THE SHOP'S AT MERIDIAN RANCH

FILING NO. 1, LOT 4
SITE DEVELOPMENT PLAN
EL PASO COUNTY, COLORADO.
FALCON, COLORADO

COVER
SITE DEVELOPMENT
PLAN

FILE NUMBER: PPR18033

THE SHOP'S AT MERIDIAN RANCH

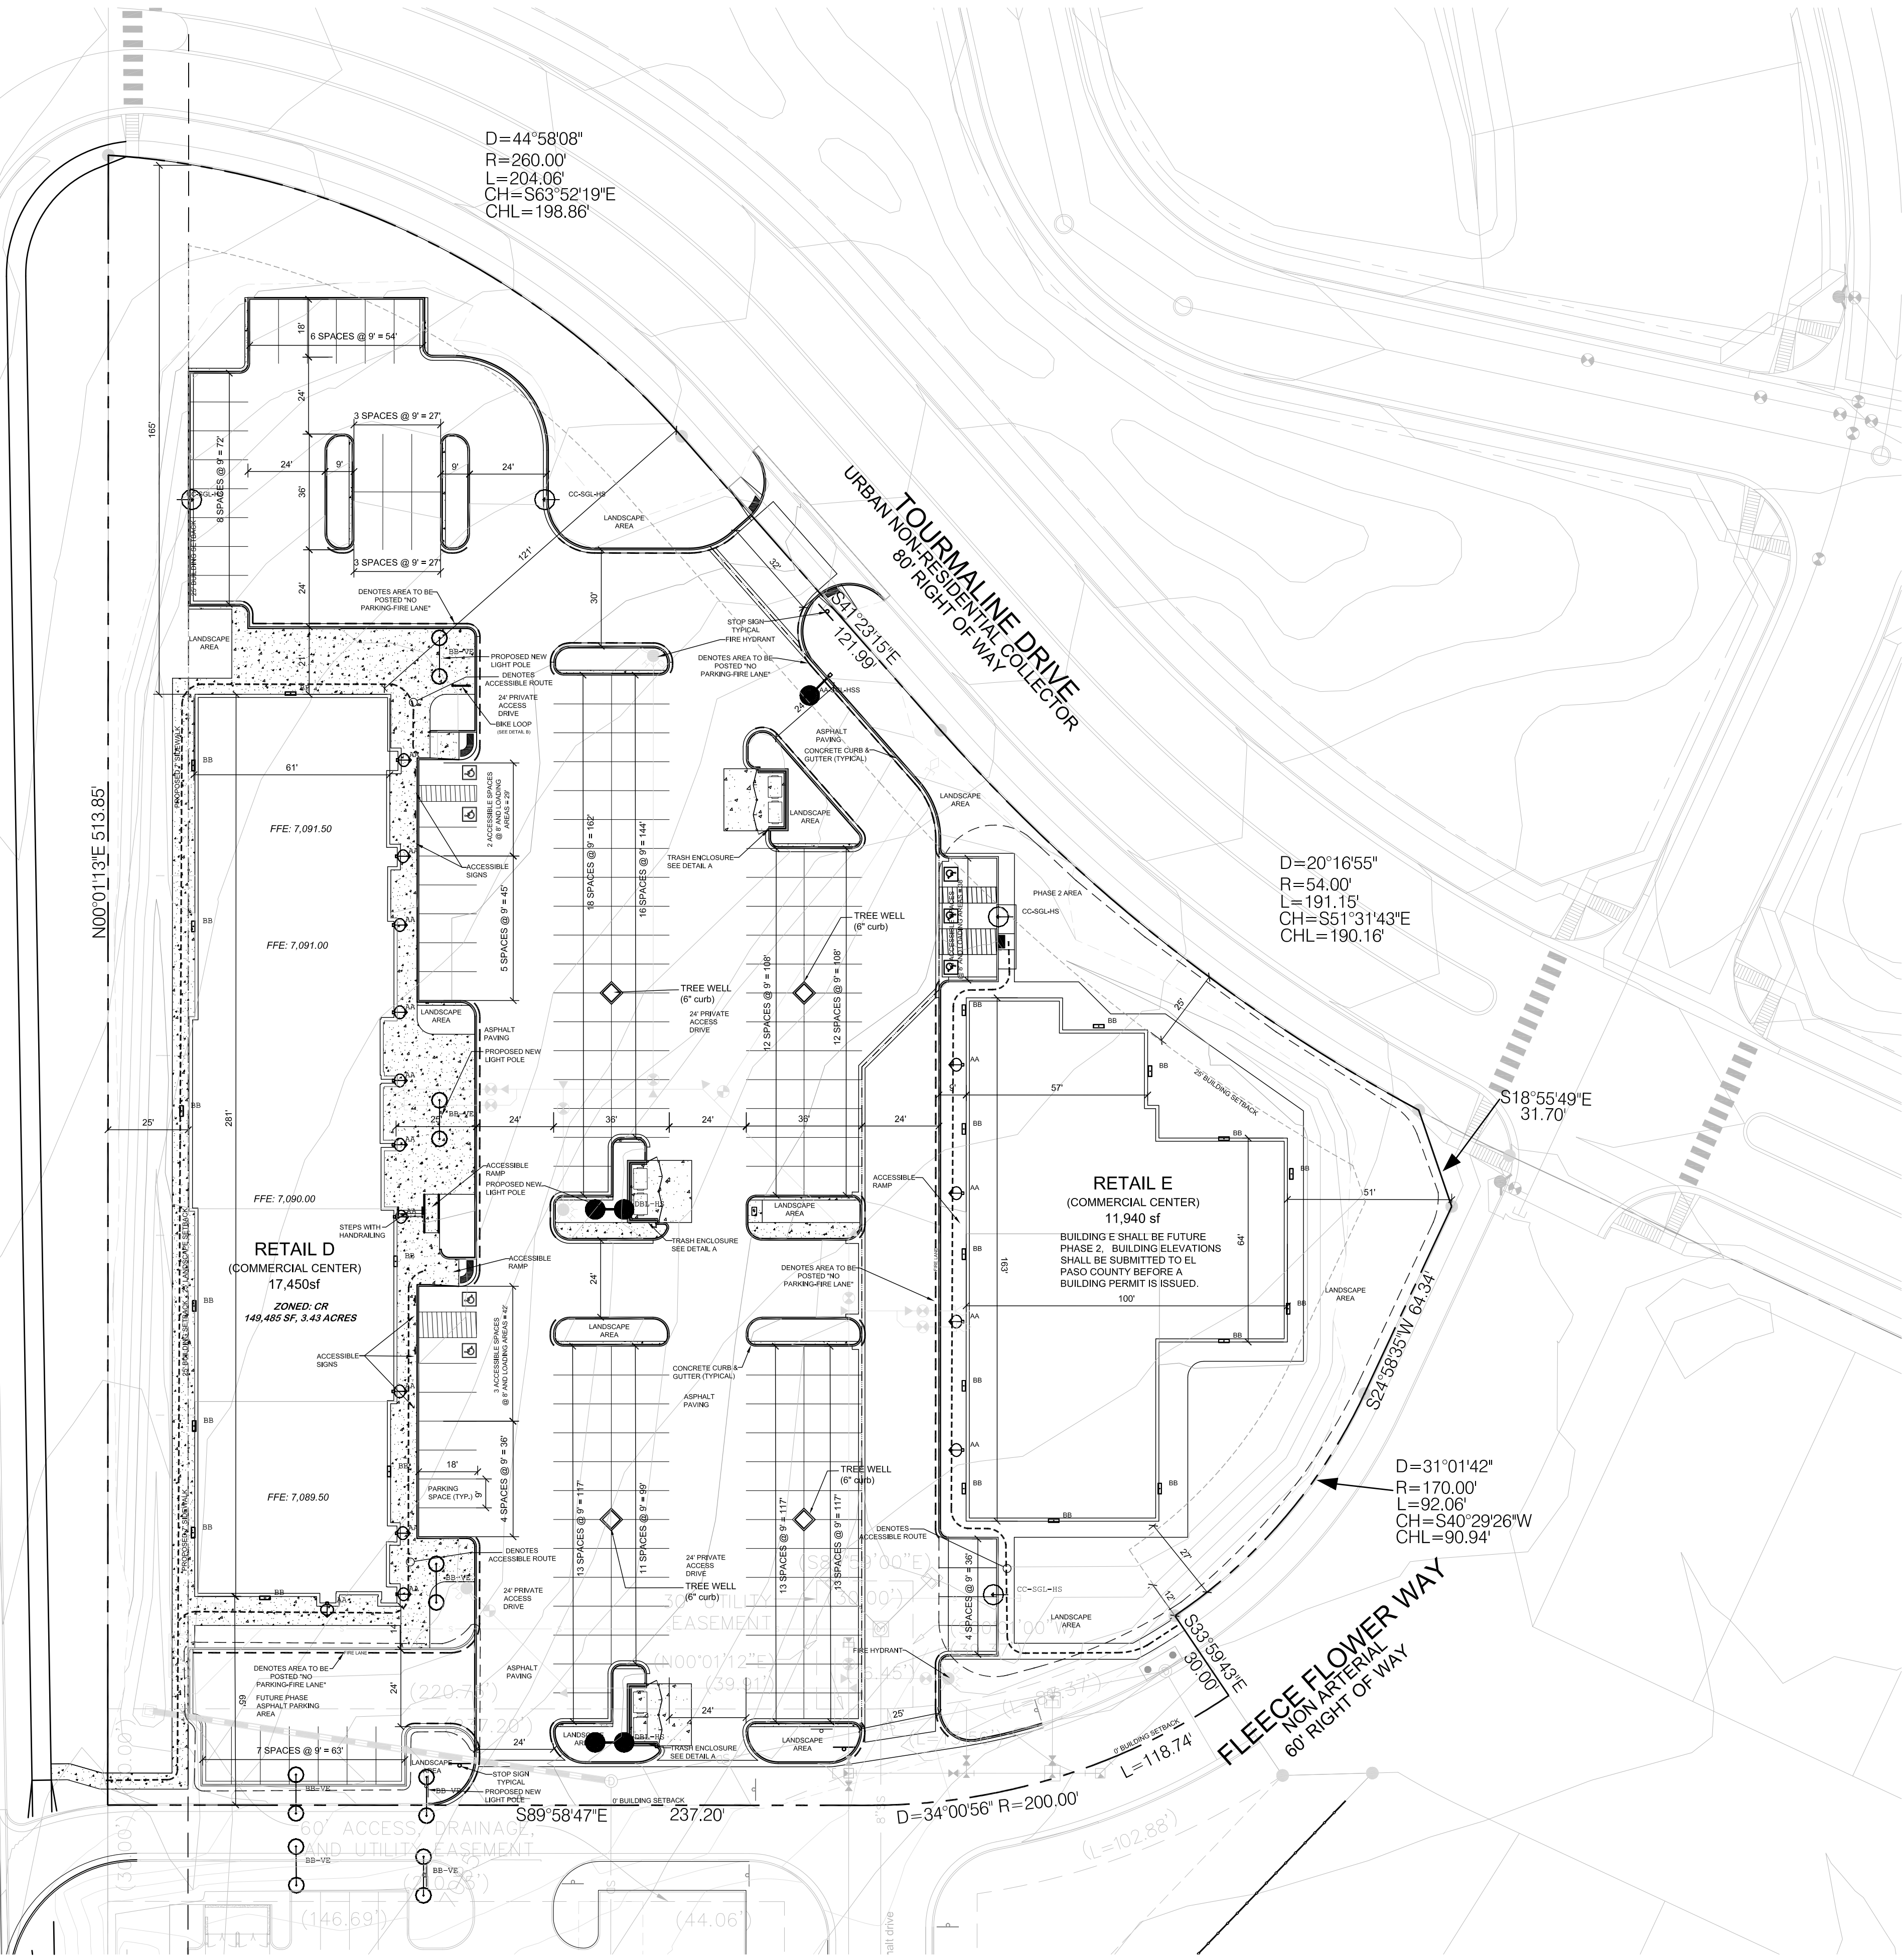
This should be shown as the drainage and access easement, please identify it like the 30' utility easement that is called out.
